Recommendation: Approve

Applicant: GreenSquare Homes Ltd

Proposal: Reserved matters application to 18/00792/OUT - for the demolition of existing buildings and erection of up to 46 no. dwellings, with associated works and provision of open spaces

**Plates 13 & 14:** further cankers and structural defects noted within the crown of T8.

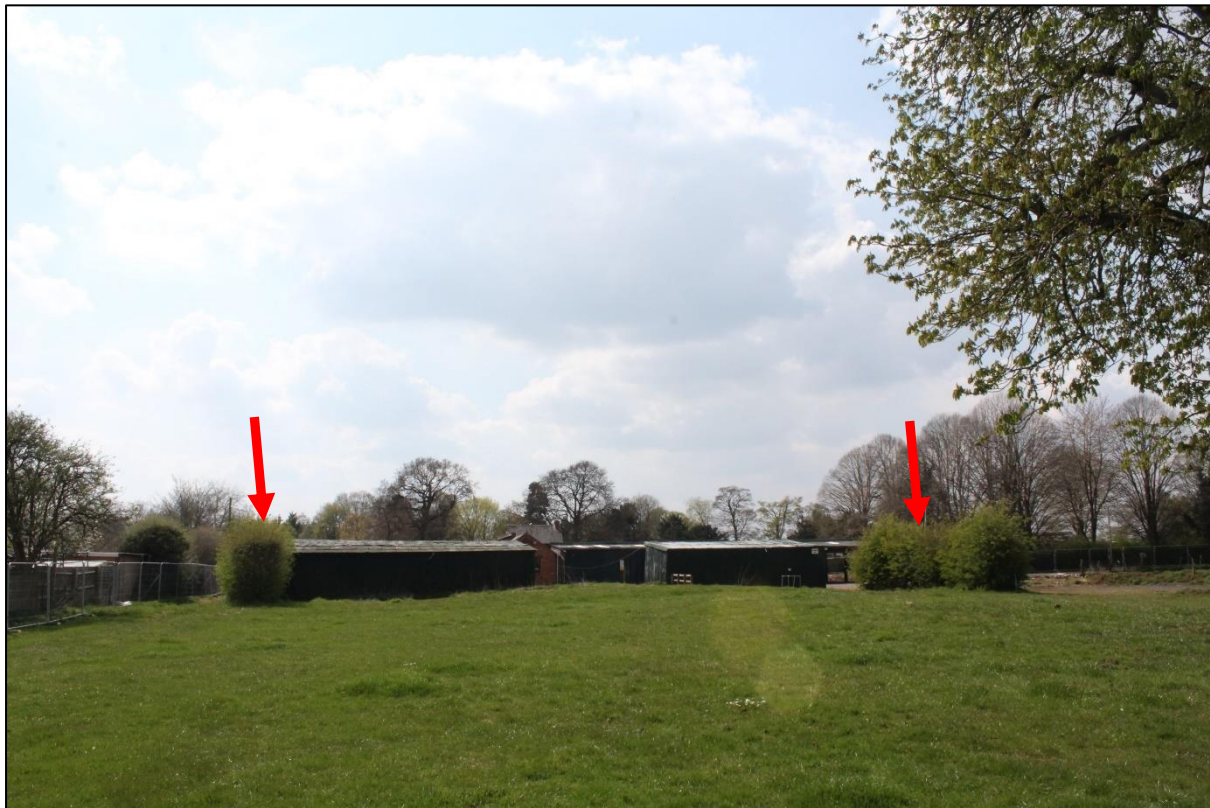
- 8.12. Having considered the impact of the development on T8 the Horse Chestnut in the centre of the site which was compromised in the initial submission being placed within a private rear garden and immediately adjacent other private rear gardens too, a revised submission was submitted for consideration in October 2021. This revised layout however resulted in a very contrived development. Whilst this layout showed the tree within an area of open space, it was not clear how the area was to function. It provided an awkward parking arrangement for plots 43 and 44, and poor visibility and legibility in terms of visitors, deliveries and removals etc. The parking court also appeared generally tight in terms of parking and manoeuvring and refuse collection. Concern was also raised that the tree still lacked sufficient room to grow and mature and as shown would appear visually within what is essentially an open car park visible from the main street and the open space to the Oxford Road boundary. The applicant was advised that as a consequence of the proposed layout, the rear gardens were also compromised in this area.

- 8.14. Following further discussions, to help resolve the issues raised above, the applicant was advised that consideration would be given to the removal of T8 (Horse chestnut), but only if its condition and longevity could be justified and that the layout in this area was significantly improved as a result.

Update: 22.03.2022 – the removal of the TPO'd Red Horse Chestnut is justified and it is proposed it will be replaced by several trees. Happy with the submitted Method Statement and Tree Protection Plan and landscape proposals. There will be some shading issues, but this is unavoidable. Suggest conditions are attached relating to protection of retained trees, AMS and tree pit detail.

- 8.15. It is considered that the layout, which does now show the removal of T8 is significantly improved and is now acceptable. The removal of this tree has also been agreed by the Arboriculture officer.

LEGEND

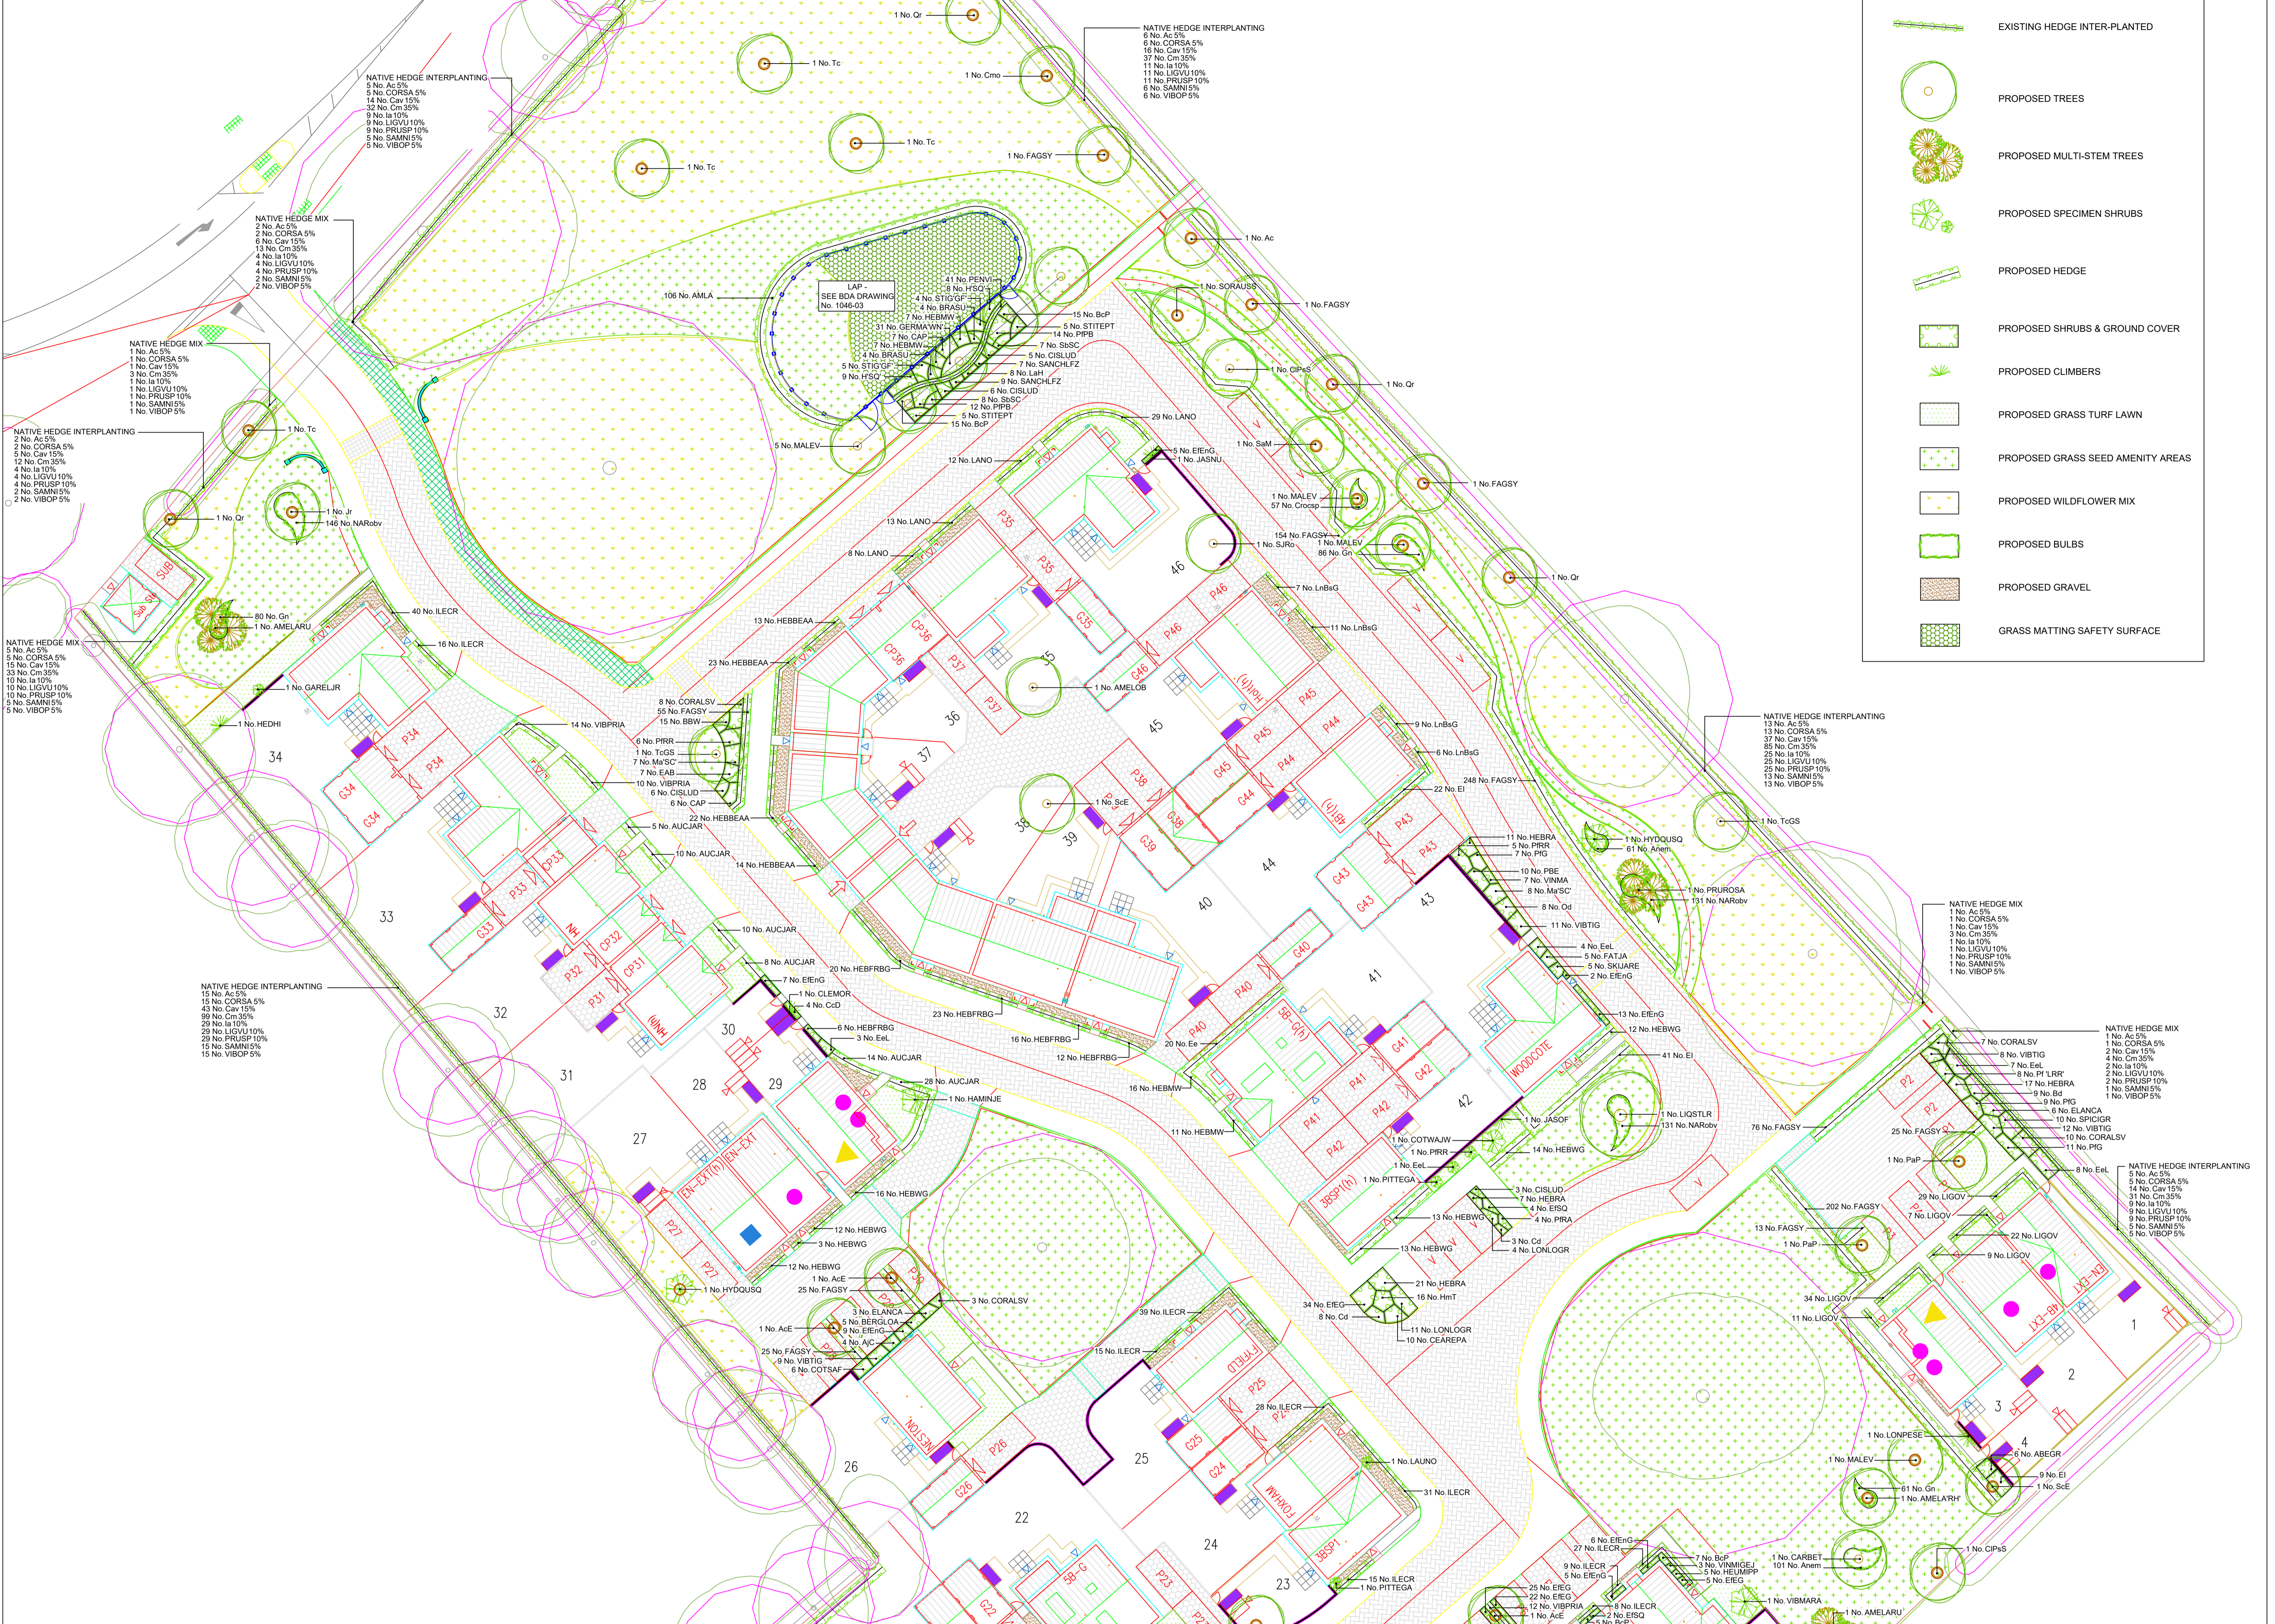
- 8.39. In terms of the proposed landscaping proposals, the initial submission which was assessed by the Council's Landscape Officer was not considered acceptable for a number of reasons. These being; the proposed extensive beech hedging will require regular maintenance and can look unsightly if gaps occur due to failures. The open space should not be contained by dense hedges although a barrier will be required to prevent encroachment by vehicles. The applicant was advised of these concerns which can be read in full on the application file. The latest submission has addressed these and is now acceptable in this respect.

PLAY EQUIPMENT

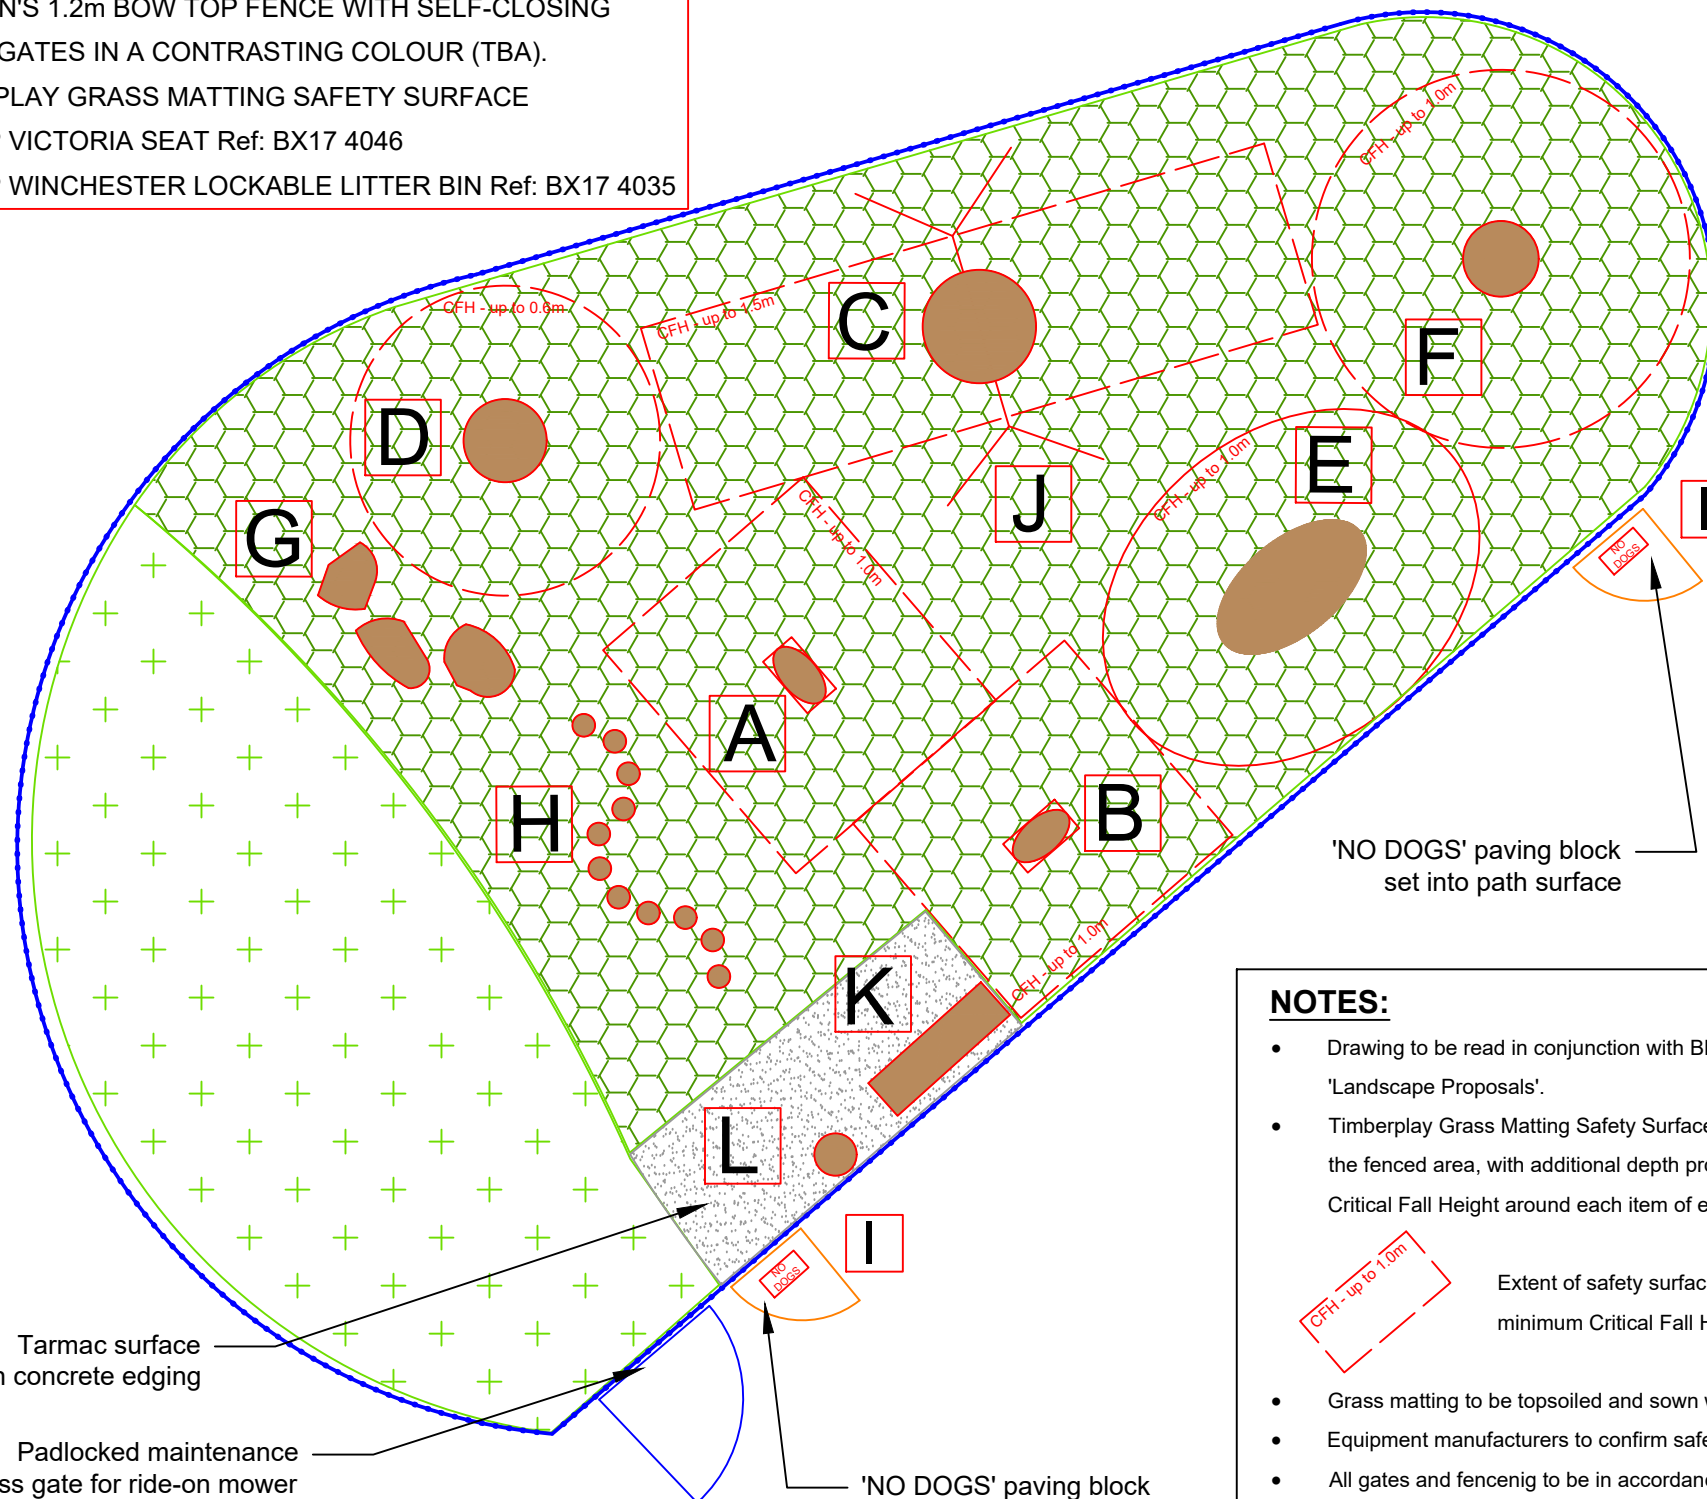
Update: 17.03.2022 – details of the LAP require amendment.

- 8.40. The original submission also indicated the position of the LAP to be provided at the southern end of the site, however, as shown there was little opportunity for surveillance and the area of open space felt disconnected and isolated from the remainder of the development and Bodicote village itself. It was also placed directly along the garden boundaries with the existing development which was not considered appropriate in terms of noise and disturbance to the occupiers of those properties which did not have direct access to it. The detail and size of the LAP did not comply with CDC guidance. The LAP is now shown within the open space at the front of the site to White Post Road which is considered to be more appropriate.
